Submission No.			This cover letter is common to OPW Submission No.'s 213 to 240.	
Organisation Name or Name of Submitter			Office of Public Works (OPW)

Item No.	Section Ref.	Page No.	Observation Statement	TII Response
OPW Cover Letter - Re: Railway (Metrolink–Estuary to Charlemont via Dublin Airport) Order 2022 – Submissions by the Commissioners of Public Works in Ireland				
1	Cover letter - Legal Requirements	2	<p>Critical aspects of this project relating to physical construction methodologies have not yet been determined and, therefore, a full analysis of any impacts on properties is not possible. In that regards submissions are only possible and limited to the information that has been made available at this juncture.</p> <p>As noted above, the OPW is supportive of the Metrolink project. However, this is subject to all statutory requirements being complied with, in light of the Commissioners’ duties under the Commissioners of Public Works (Functions and Powers) Act 1996 and other Acts.</p> <p>Therefore, the confirmation of the Railway Order should ensure that the proposed Metrolink project properly falls into one or more of the criteria in s.116 of the 2008 Act.</p>	<p>TII wel

ST. STEPHENS GREEN STATION

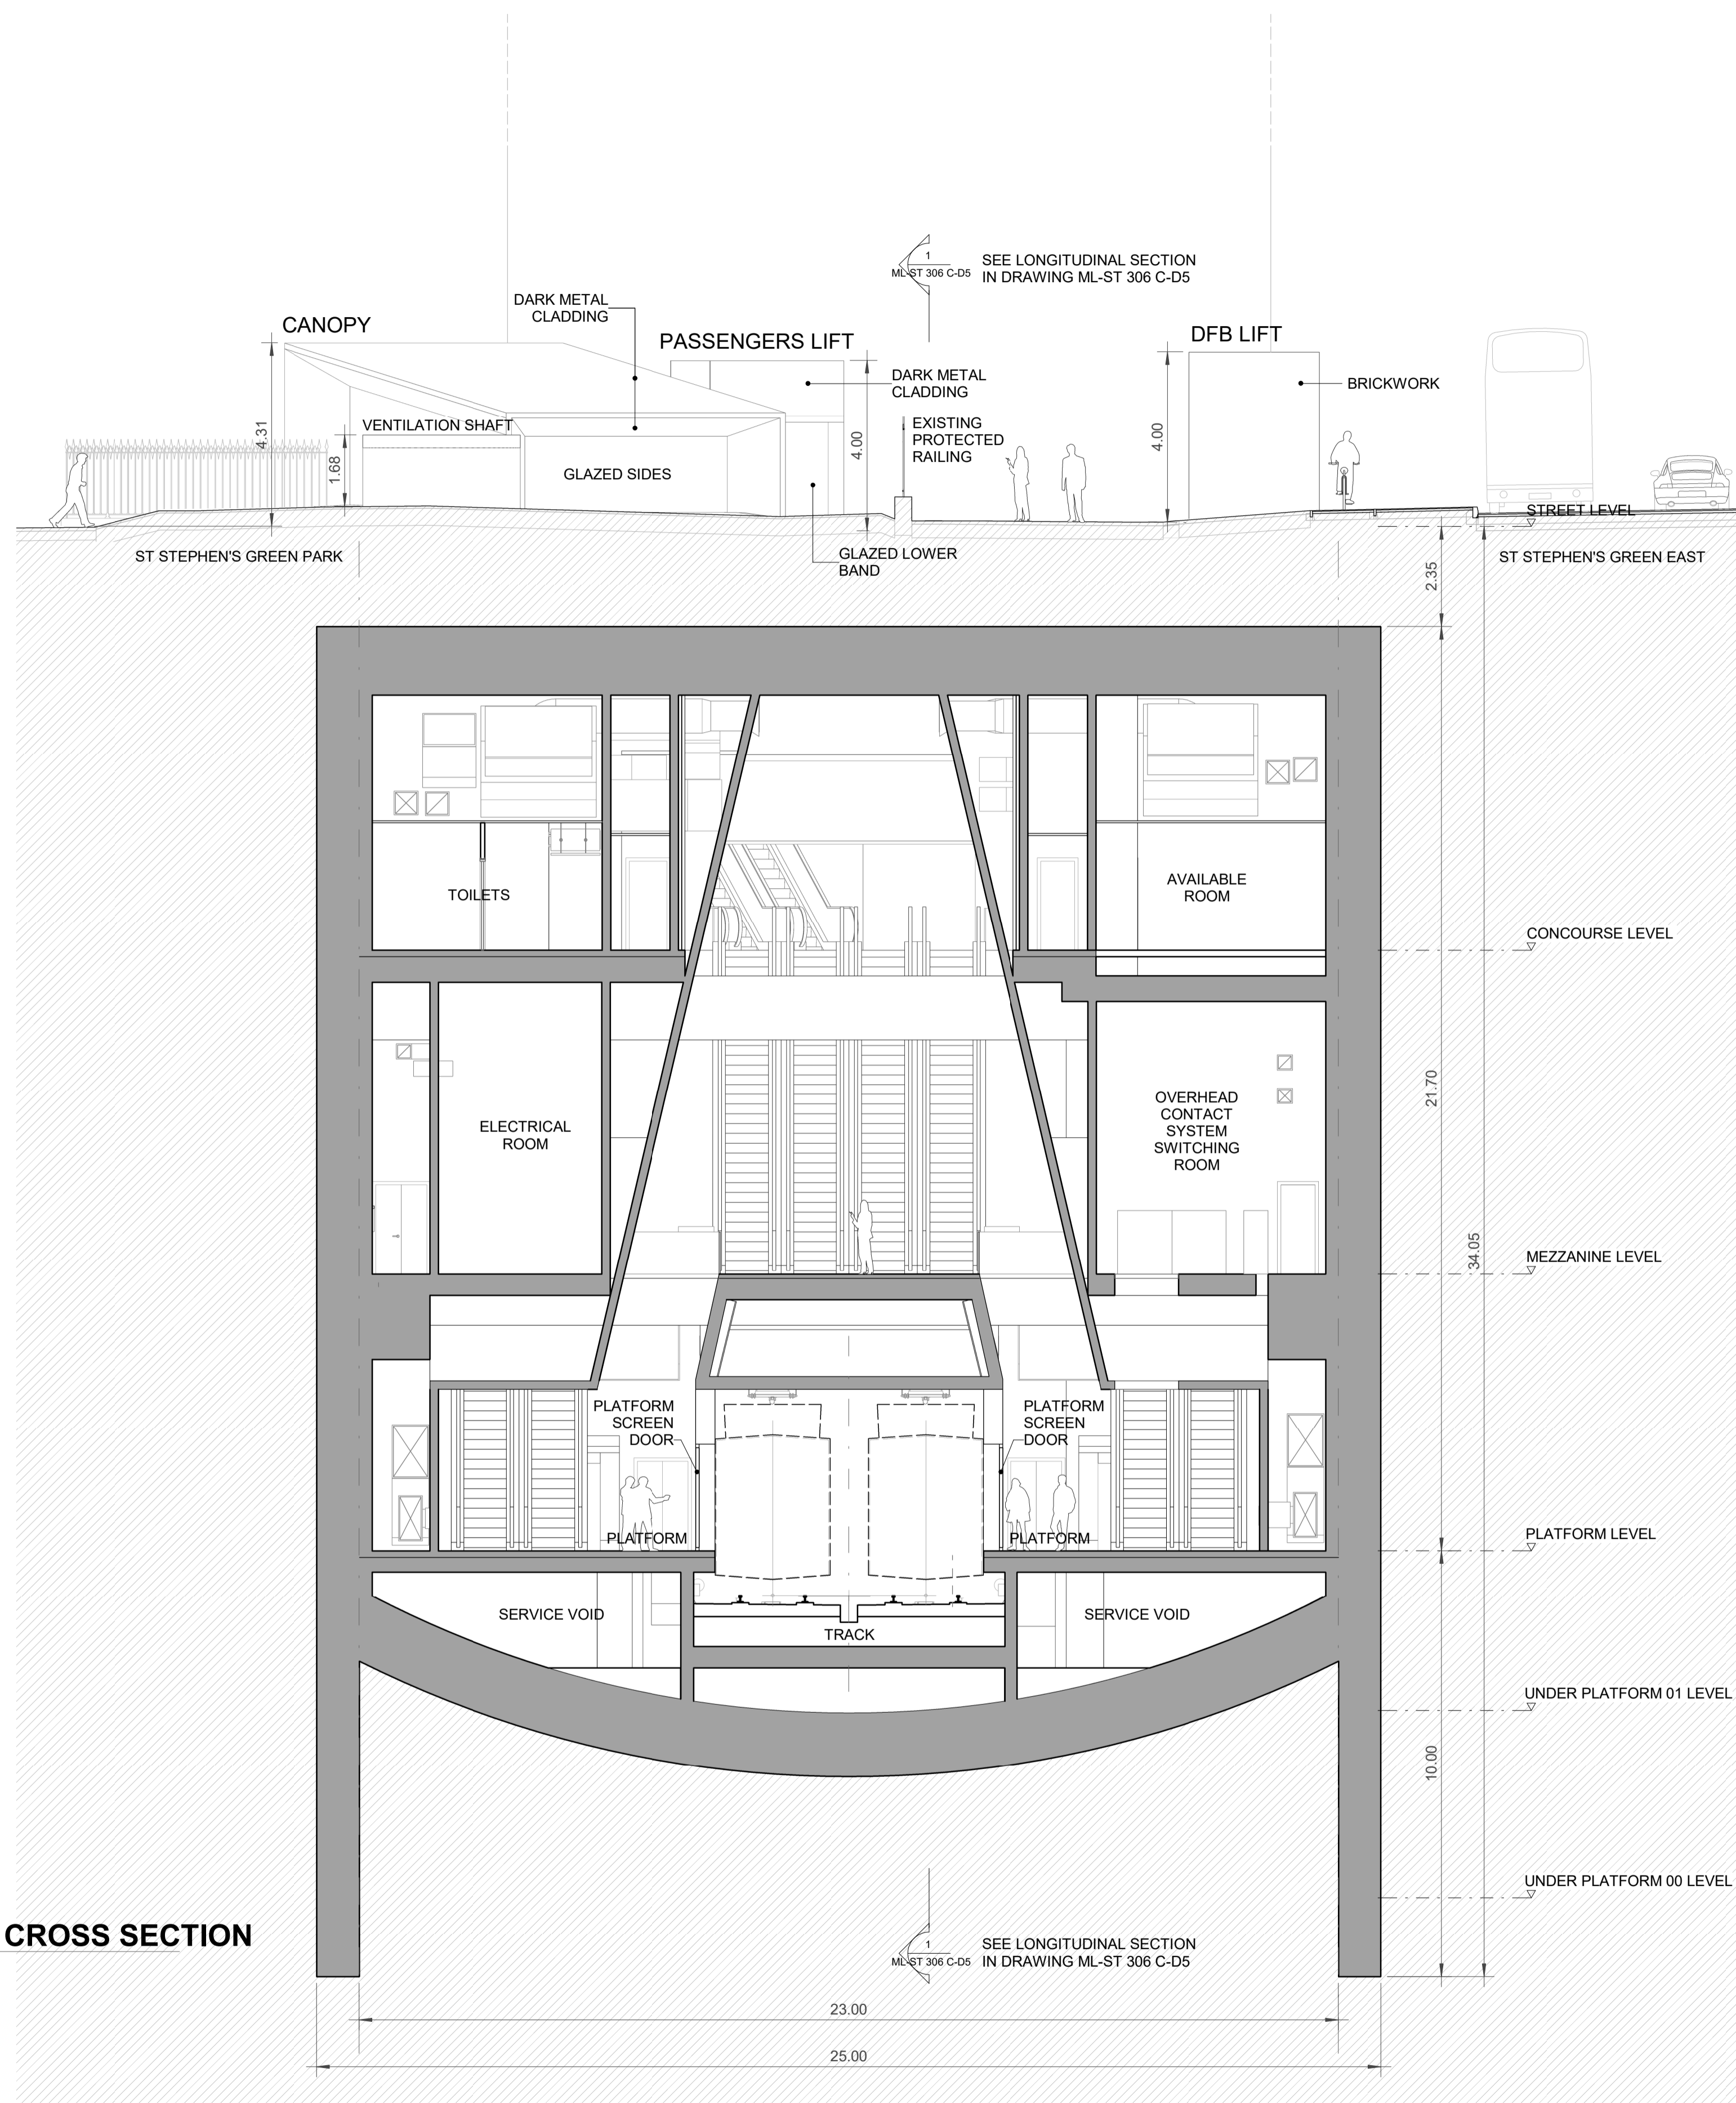
2	Executive Summary	N/A	<p>The current proposal is to site a station within the Green and the EIAR identifies the significant effect that this will have on this National Monument:</p> <ul style="list-style-type: none">• Chapter 25 Archaeology and Cultural Heritage characterises the effect as very significant direct negative (permanent) during the Construction Stage and very significant indirect negative during Operation Stage.• Chapter 26 Architectural Heritage characterises the effect as profound direct negative during the Construction Stage and very significant indirect negative during Operation Stage.• Chapter 27 The Landscape characterises the effect as very significant negative during the Construction Stage and very significant negative during Operation Stage.	<p>Options assessed include alternative MetroLink alignment options through this area with alternative station locations, alternative station locations at St. Stephen’s Green East, and alternative construction methodologies such as mining. The preferred station location of St. Stephen’s Green East was chosen as it minimises the potential impacts on the Park when compared to other options with a larger footprint in the Park. The preferred option occupies c. 5% of the Park area during the construction phase, reducing to just 0.2% of the Park during the operational phase. In addition, all heritage features such as monuments, railings, bollards, and paving stones can be fully reinstated following the construction phase.</p> <p>Appendix A 7.5 to the EIAR presents an analysis of the alternative construction methodology of mining the station which would allow for construction of the station with a smaller footprint at ground level. However, these options were ruled out as they would increase the construction phase (and as a result environmental impacts) by between 2 and 3.75 years and they would ultimately make it not possible for the Project to achieve its objectives of providing a high quality operational station.</p> <p>The location of the station has been chosen and carefully designed to ensure that St Stephen’s Green East continues to function as an important transport route, as an important corridor for critical utilities such as water, electricity and sewage, and as an important location for commercial and business activities. Ensuring this critical functionality on this side of St. Stephen’s Green would have been prolonged and very difficult to achieve with Location 8 that was located entirely outside of the Park. This option also negates the potential for direct impacts on properties to the east side of St Stephens Green East road, on critical utilities including a major Victorian sewer, and on the roadway which is an important access route to the city centre, particularly for public transport.</p> <p>It is acknowledged in Chapter 27 of the EIAR that the reinstatement of trees removed will take a significant period of time to re-establish. However on completion of the construction phase, reinstatement of heritage items and replanting (and reestablishment) of trees, TII maintains that the proposed St. Stephen’s Green Station will enhance this area by providing Dubliners and visitors alike with high quality public transport access to St. Stephen’s Green and to this area of the city, thereby reducing car dependency, noise levels and improving air quality, while allowing citizens to enjoy St Stephen’s Green long into the future.</p>

5	Executive Summary	N/A	<p>The OPW notes that in The St. Stephen's Green Station – Mined Options Report (EIAR Appendix A7.5), the current preliminary design performs worst with “regards to ‘Property Impact on SSG Park’, ‘Biodiversity’, ‘Landscape and Visual’, ‘Archaeology/Cultural Heritage’, and ‘Architectural Heritage’ criteria”.</p>	<p>When TII have evaluated alternatives and options, including for St. Stephen's Green Station, impacts and benefits, both short-term temporary construction (considering the operational life span of the Project), and long-term permanent (operational phase of the Project) have to be carefully balanced, considering a wide range of criteria that cover Project Objectives, Environment, Engineering and Economy (E.g. programme and risk).</p> <p>It is not appropriate to focus solely on a particular evaluation criteria in isolation since this will not result in the optimum solution / option being selected. In the case of St. Stephen's Green Station, while TII acknowledge that the preferred station location and construction methodology for the station is not the least environmentally impactful solution for St. Stephen's Green Park, when this is balanced and considered against the long-term strategic need for and operability of the Station / MetroLink, the mined solutions are deficient in terms of; a construction programme resulting in a significant increase in the duration of MetroLink construction and environmental impacts, and not achieving the project objectives of providing a high-quality operational station, (deeper station, increased passenger walking distances and a adverse impacts on the station ventilation strategy) resulting in a very long-term permanent degradation of the MetroLink Project. This is compared to what TII would consider is a temporary impact to a very limited area of the Park that can be mitigated, and in the permanent long-term case the Park can be returned to its existing condition.</p> <p>Attention is also drawn to EIAR Chapter 7, Consideration of Alternatives of the EIAR, and in Appendices to the Chapter (A7.3, A7.5, A7.7 and A7.8). It is very important to recognise and is evident, that a significant level of analysis was undertaken to identify alternatives, 16 alternatives (10 cut and cover, 6 mined) in total were considered. Each were assessed against multiple criteria to inform the determination of the preferred station location for St. Stephen's Green. This analysis considered potential environmental effects on St. Stephen's Green Park, potential effects on buildings on the east and north sides of St. Stephen's Green, on traffic and transport along St. Stephens Green East, and on critical utilities serving large areas of the city located under the road at St. Stephen's Green East. The analysis identified that the proposed station location on St Stephen's Green East partially under St. Stephen's Green Park is the preferred option because it effects just 5% of the Park area during the construction phase, reducing to 0.2% of the Park area following full re-establishment, whilst providing a station that operationally meets the requirements of the Project over its lifetime. In addition, all heritage features such as monuments, railings, bollards, and paving stones can be fully reinstated following the construction phase. This option also negates the potential for direct impacts on properties to the east side of St Stephens Green East road, on critical utilities including a major sewer (a critical piece of infrastructure) serving the Dublin population, and on the roadway which is an important access route to the city centre, particularly for public transport.</p>

Submission No.			239		
Organisation Name or Name of Submitter			Office of Public Works (OPW)		
Item No.	Section Ref.	Page No.	Observation Statement	TII Response	
OPW Cover Letter - Re: Railway (Metrolink-Estuary to Charlemont via Dublin Airport) - St Stephens Green Park					
12	Executive Summary	N/A	Section of St. Stephen’s Green directly affected by the Project, highlighted in red. Section of St. Stephen’s Green likely to be negatively impacted by the Project, highlighted in orange.	The image presented in the executive summary of the accompanying report is very misleading. It appears from the image and from the references in the submission to show "225 trees being potentially negatively impacted" and that the OPW have reviewed the Arboricultural impact assessment and identified that because trees have been surveyed as part of the project (225 of them), these trees are potentially going to be negatively impacted. This is not the case. The potential impacts identified within the relevant chapters of the EIAR are based on the identified fact that 64 trees will be felled (and replaced after completion of construction), and that all other trees within the Park will be retained and not be impacted. Furthermore the proposed construction of the station at St. Stephen's Green will occupy a maximum of 5% of the Park area and as such will not preclude the Park outside of this area being used as normal.
